Application No: AB/134/21/HH
Site Address: 11 Wheelwrights Close Arundel BN18 9TA
Description of works: Installation of 5 triple glazed windows. (This application may affect the character and appearance of the Arundel Conservation Area).

Thank you for your internet representation made on 1st December 2021 which has been recorded as an objection with the comments as follows:

GENERAL ARRANGEMENT
DRAWING

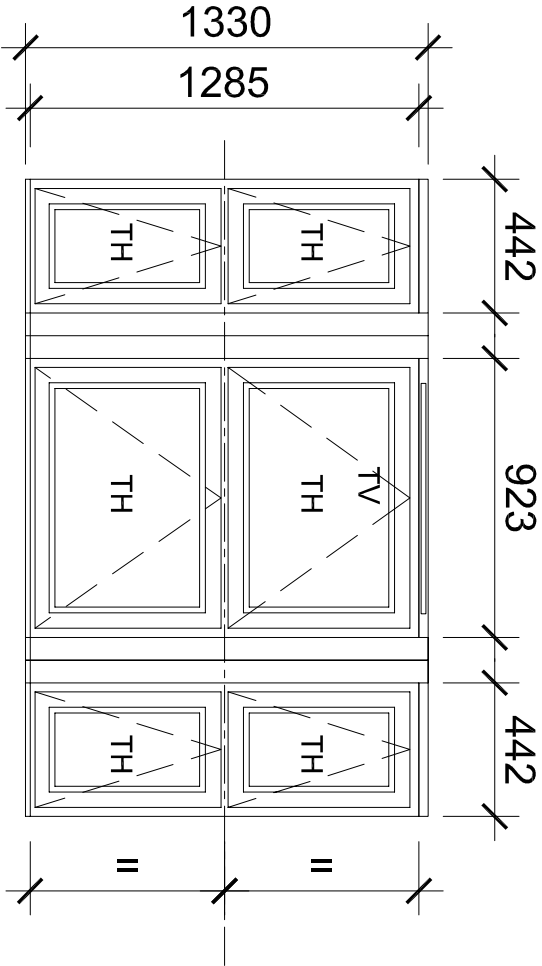
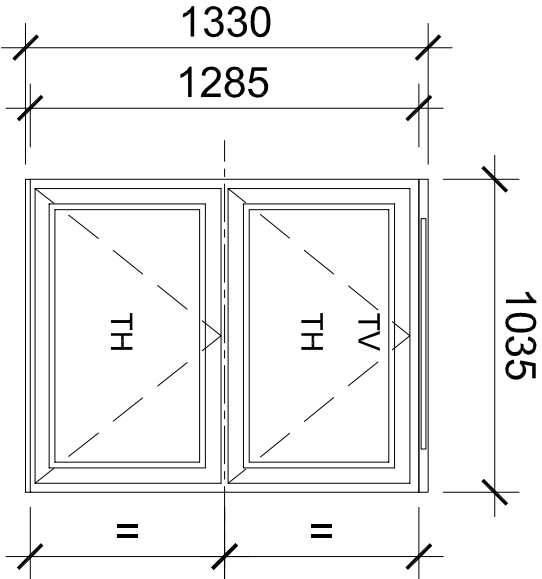
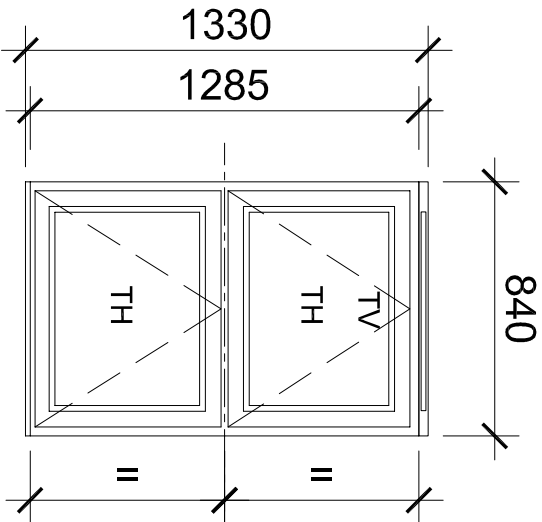
The Committee objected to this application however the Committee would not have objected if the triple glazed windows were sash windows instead of casement windows which would be more in keeping with the other houses in the close, and in the conservation area generally.
